# Rezoning Transportation Analysis

Petition Number: 2019-177

Date	Description
01-15-2020	First Review
02-17-2020	Second Review
04-23-2020	Third Review

RZ-1

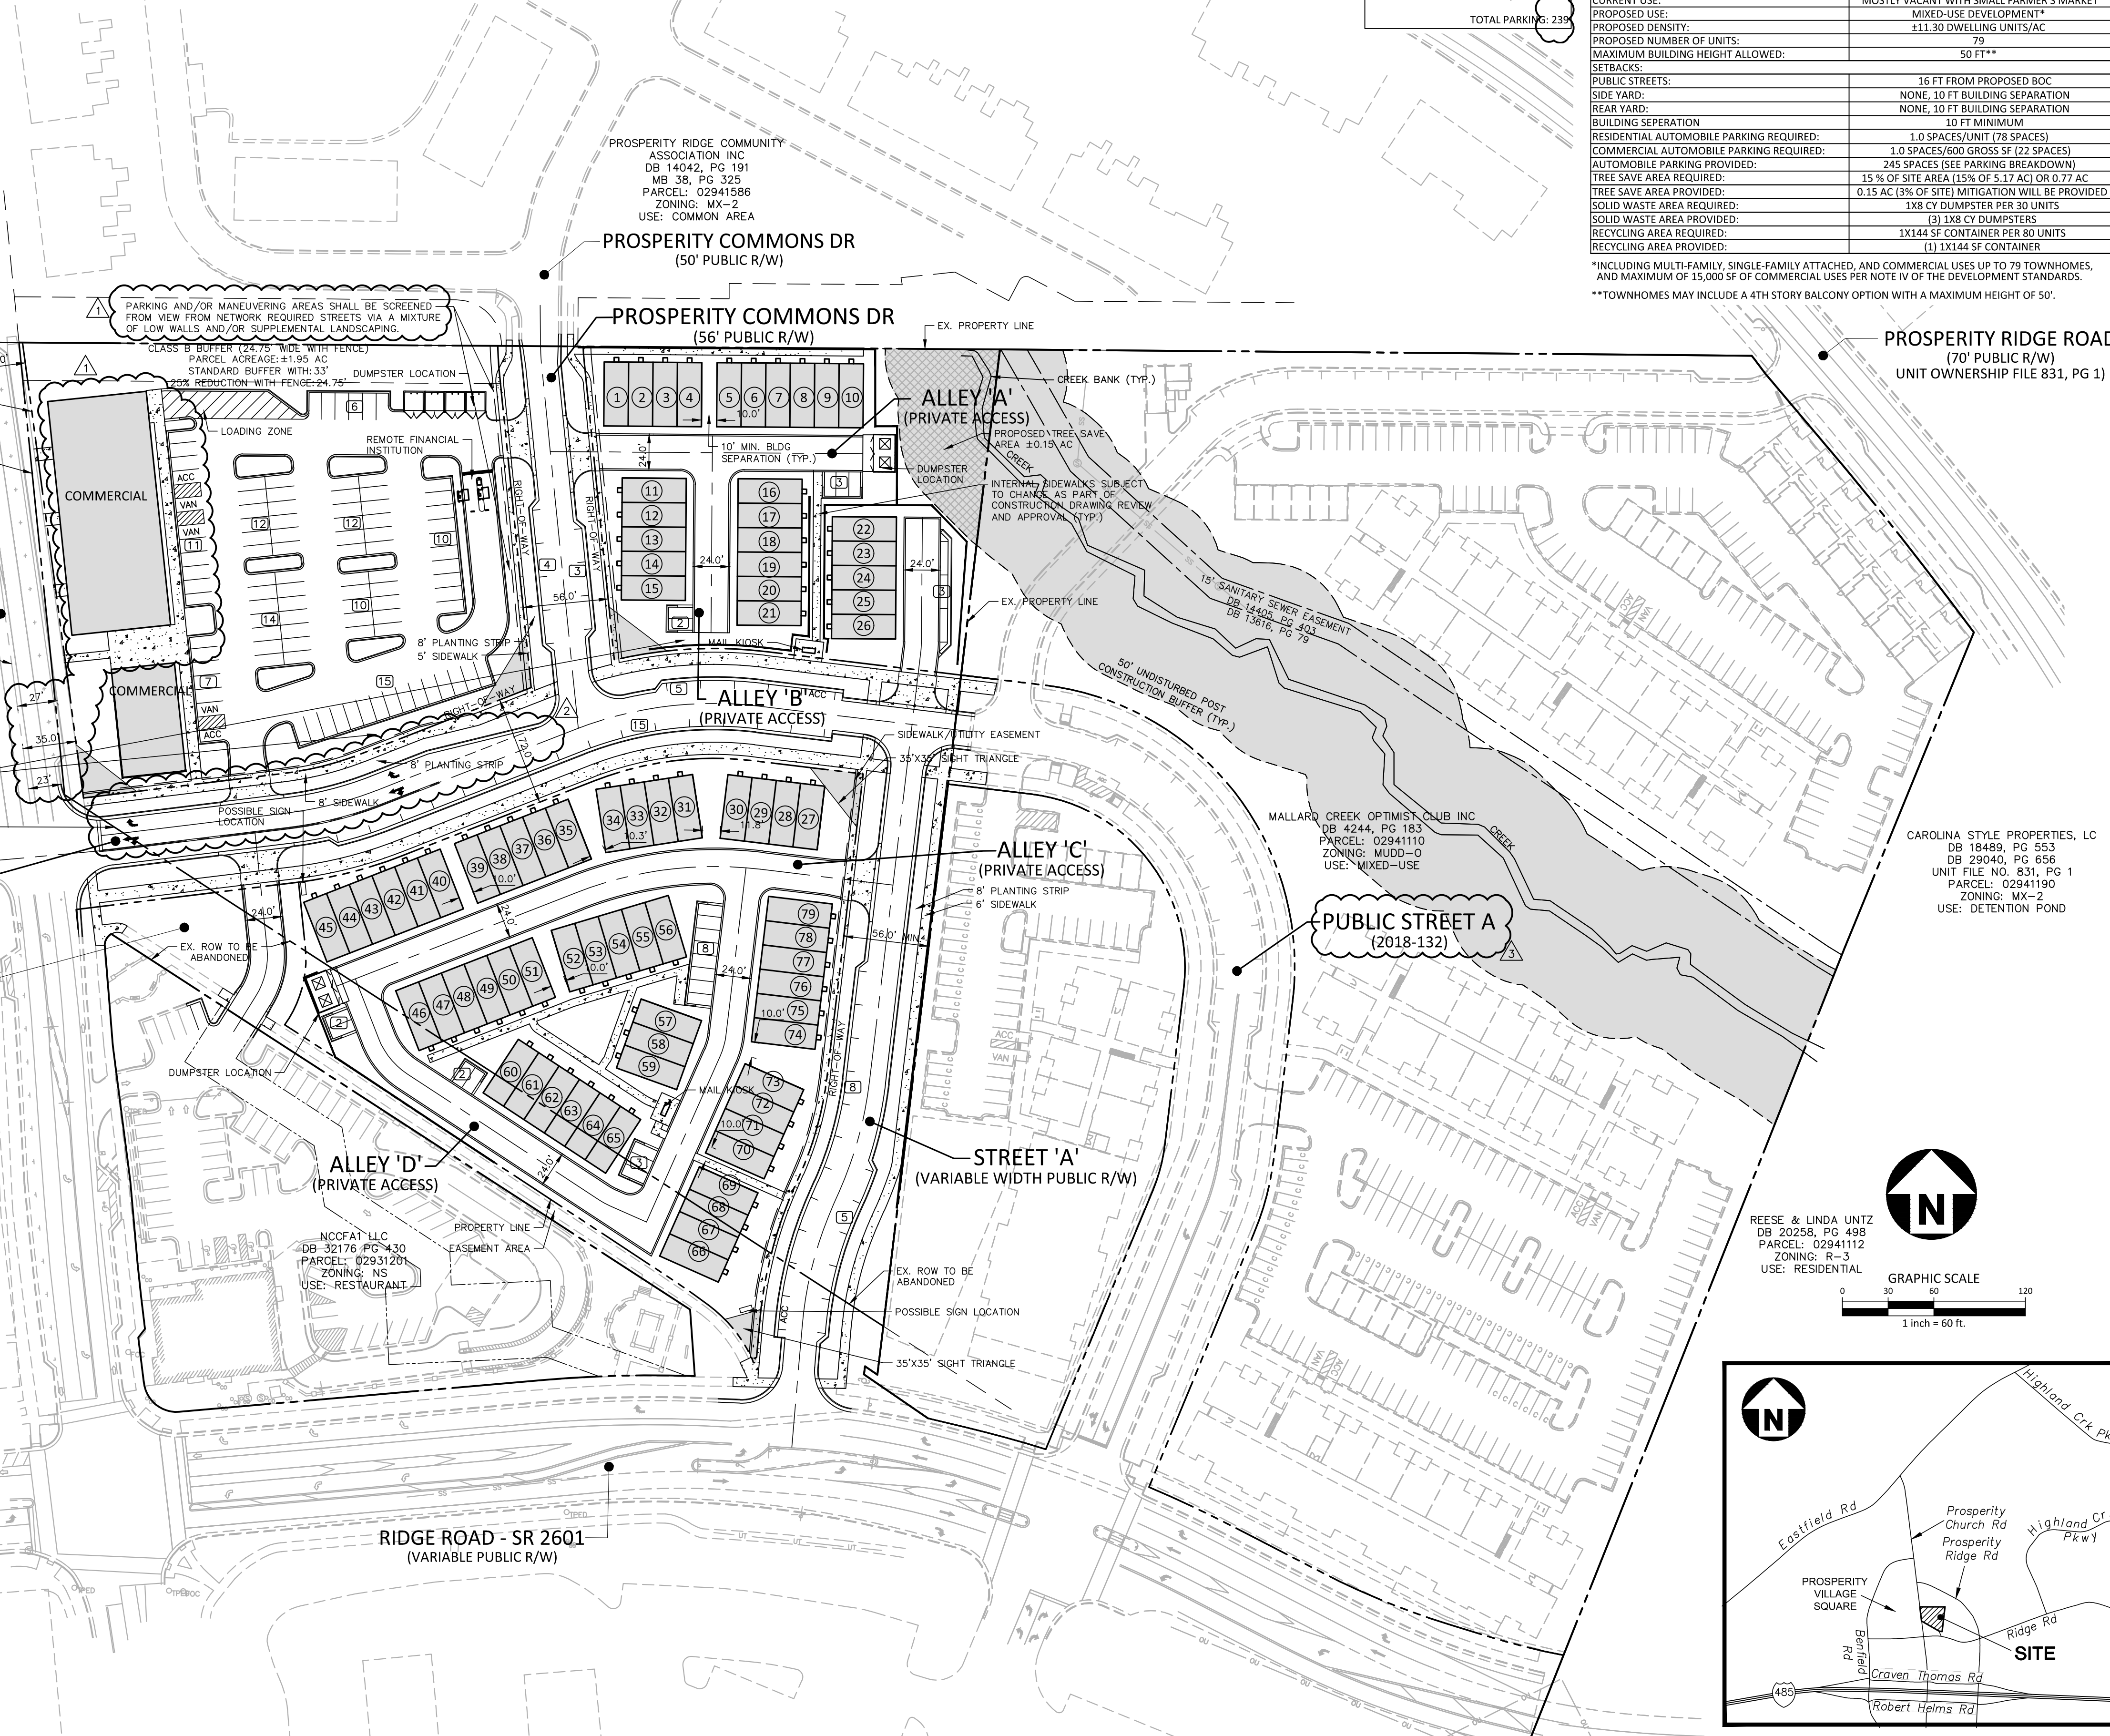
1. ~~**Curbline** The proposed zoning district has a setback measured from back of the existing or proposed future curbline.~~
  - a. ~~**Prosperity Church Road:** Location of future back of curb and gutter needs to be installed 18.5' from centerline.~~
  - b. ~~**Ridge Road:** The future location of curb and gutter is in its existing location.~~

~~The site plan should show the curb and gutter labeled and dimensioned from the centerline for each road.~~
